16 August 2017

**Subject: Sydney Metro Martin Place Station Precinct, State Significant Development Application
Response to public submissions relating to heritage issues**

OPPORTUNITIES FOR LINKS WHICH ARTICULATE OLD AND NEW

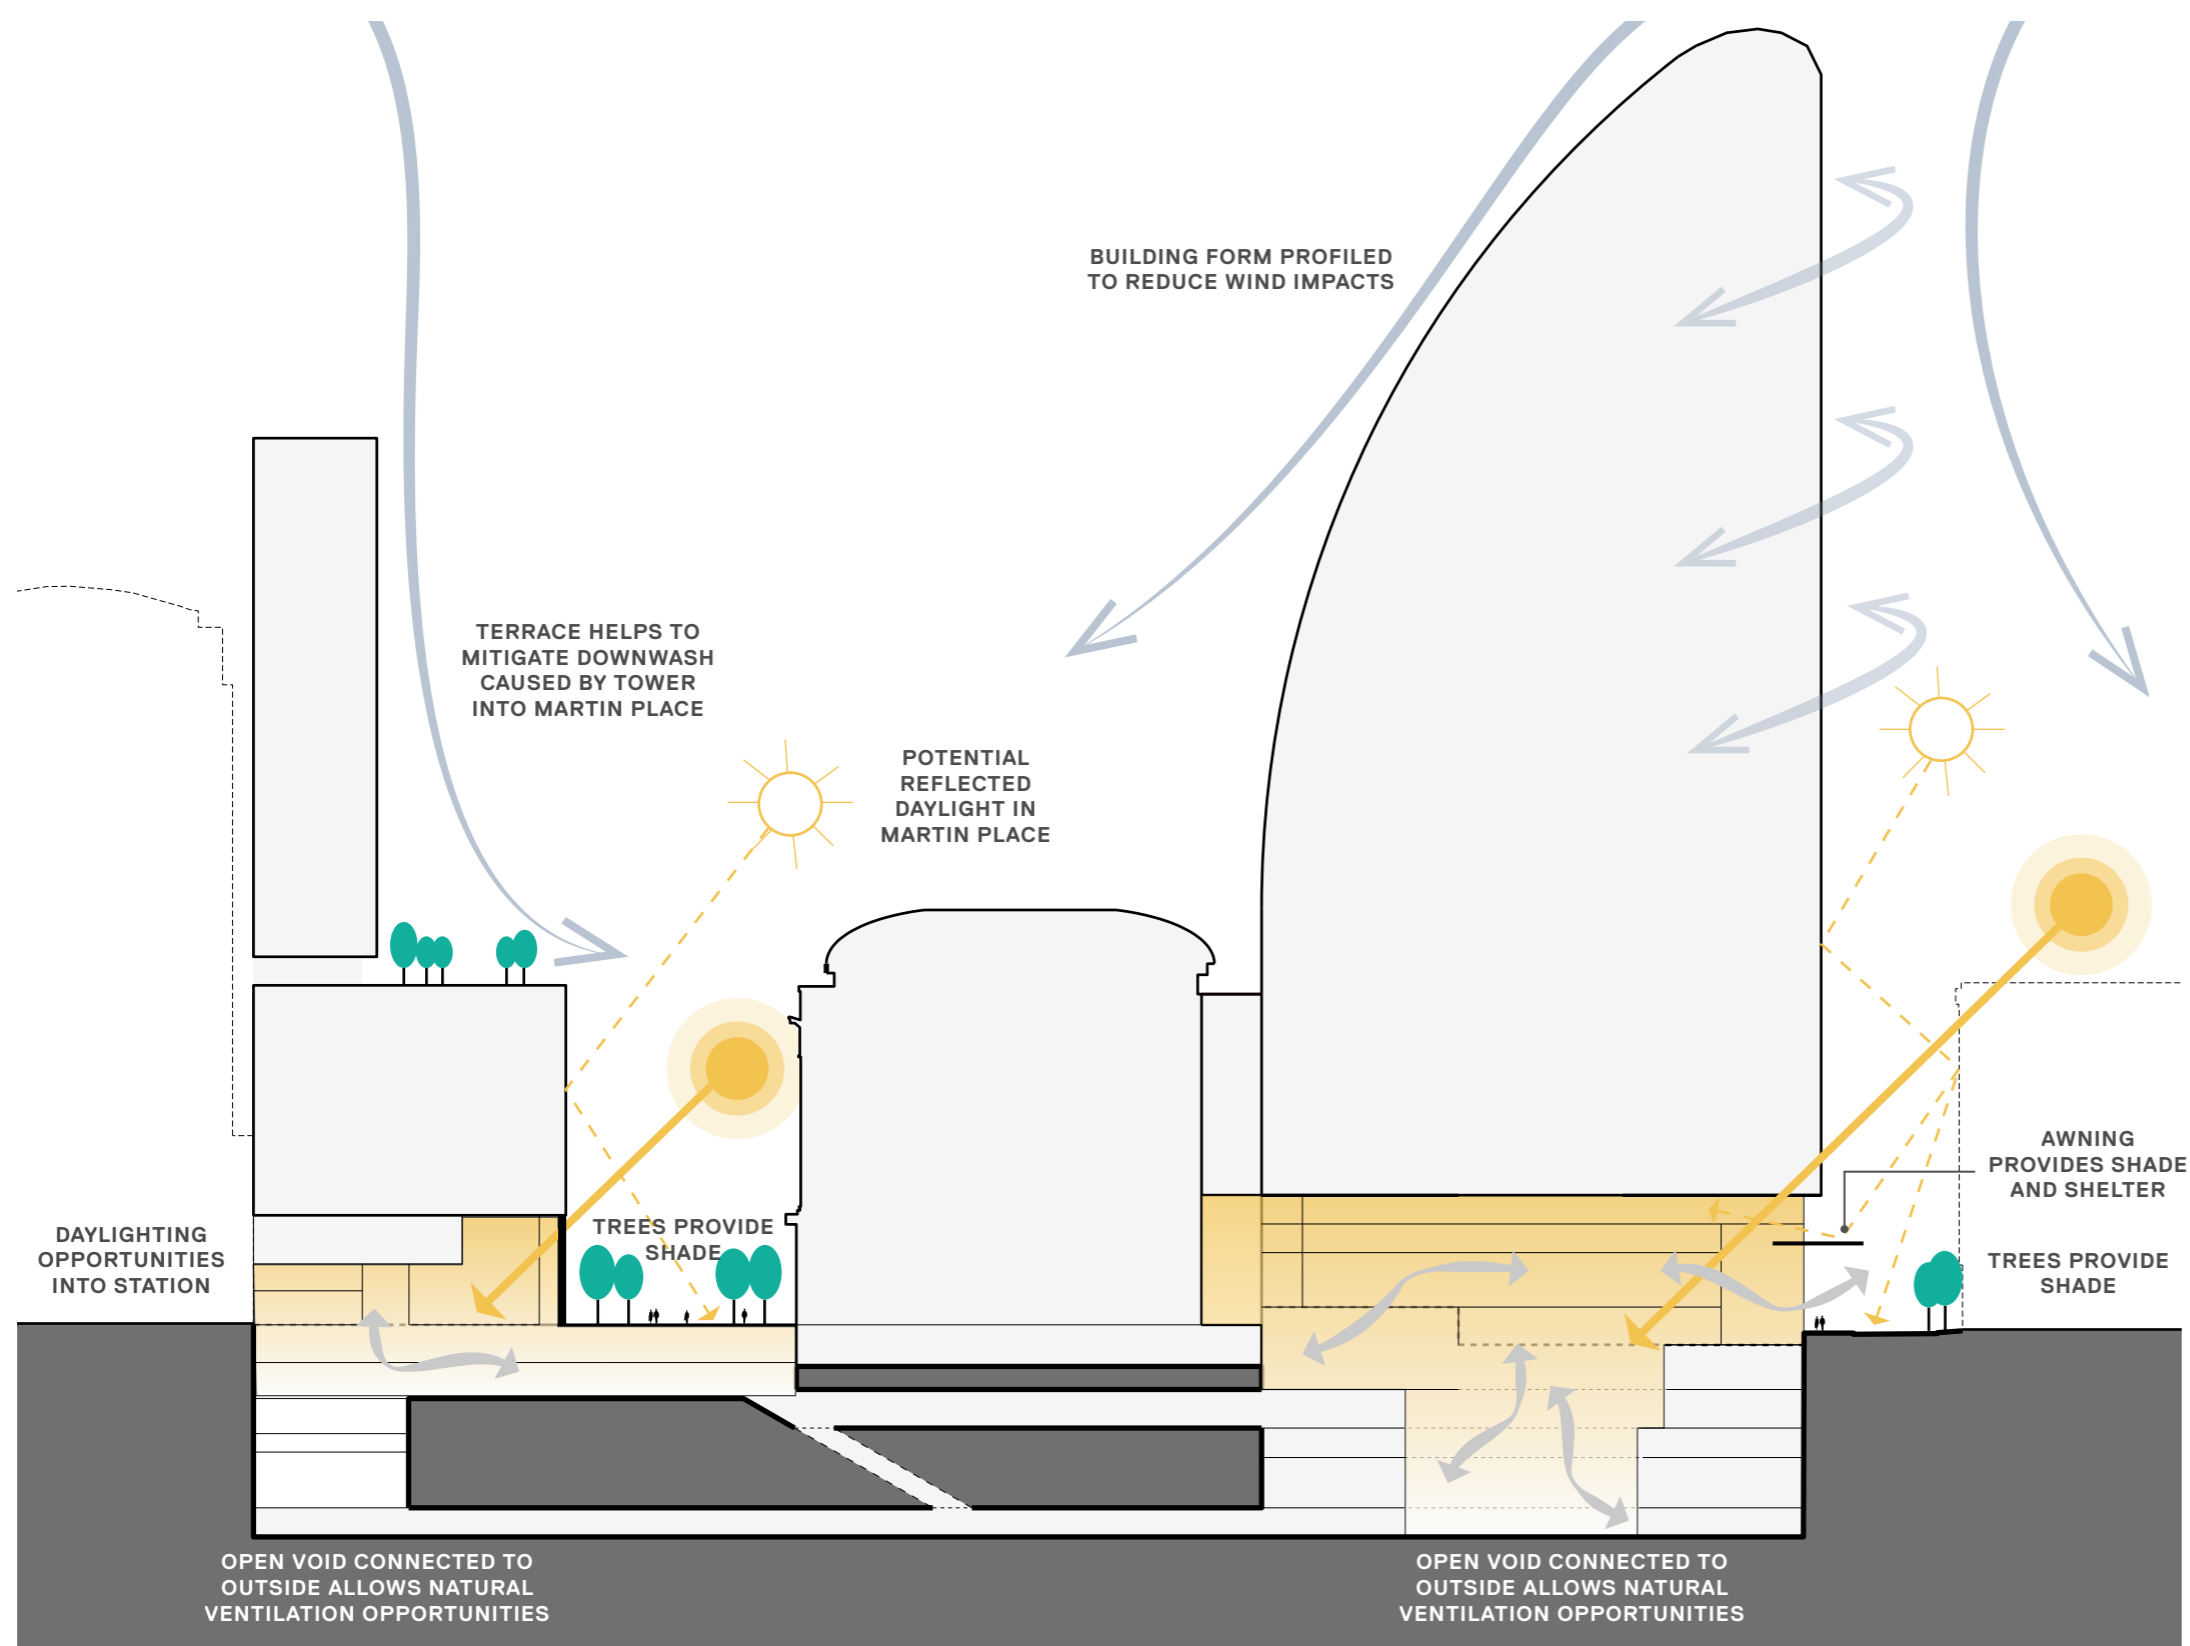
Provide details showing how the north tower building envelope will physically connect into 50 Martin Place. This should include indicative plans and / or illustrations showing the existing and proposed connections, and an assessment of these connections on the heritage significance of 50 Martin Place.

Presently, there are five connections between 50 Martin Place and the adjoining 1967 building at 9-19 Elizabeth Street. The interconnecting openings are intrusively located at the landings of the original and significant north-east stair at levels 1, 3, 4, 5 and 7. The development proposal provides the opportunity to remove these openings and reconstruct the stair to its original configuration: the openings will be infilled and tiled to match the original historic tiles.

Three connections are proposed between 50 Martin Place and the future building on the north site: at ground floor (within the Grand Hall), through the northern lightwell at Level 5 and at rooftop Level 10. These are areas of the building identified as having exceptional heritage significance (Grand Hall and Level 10) and high significance (the northern lightwell at Level 5).

In consideration of the exceptional heritage significance and integrity of the Grand Hall, the proposed connecting opening is required to be carefully designed in order to maintain the spatial quality of the Hall and to minimise alteration of its historic fabric. Key considerations include ensuring an appropriate scale, proportion and location of the opening, in order to retain the predominant east-west axial quality of the space and to relate visually to its architectural design; the use of details and materials which complement the high quality of the historic finishes, and; ensuring that the works are reversible through the salvage and storage of removed original fabric, for potential future reinstatement. Heritage design guidelines are provided in the Statement of Heritage Impact (p. 58).

At Level 5, a connecting bridge link is proposed to be located where there is presently a window which was installed as part of the 2014 refurbishment works. No historic fabric is required to be removed.

A connecting bridge at Level 10 will require the enlargement of a non-original window within the northern end of the historic rooftop colonnade. The window was installed during the 2014 refurbishment works and replaced an earlier door opening which had been formed during the 1980s.

To minimise visual impacts within the northern lightwell, the bridge links at both levels 5 and 10 are proposed to be of glass construction.

Refer Supplementary Design Report for indicative plans and diagrams.
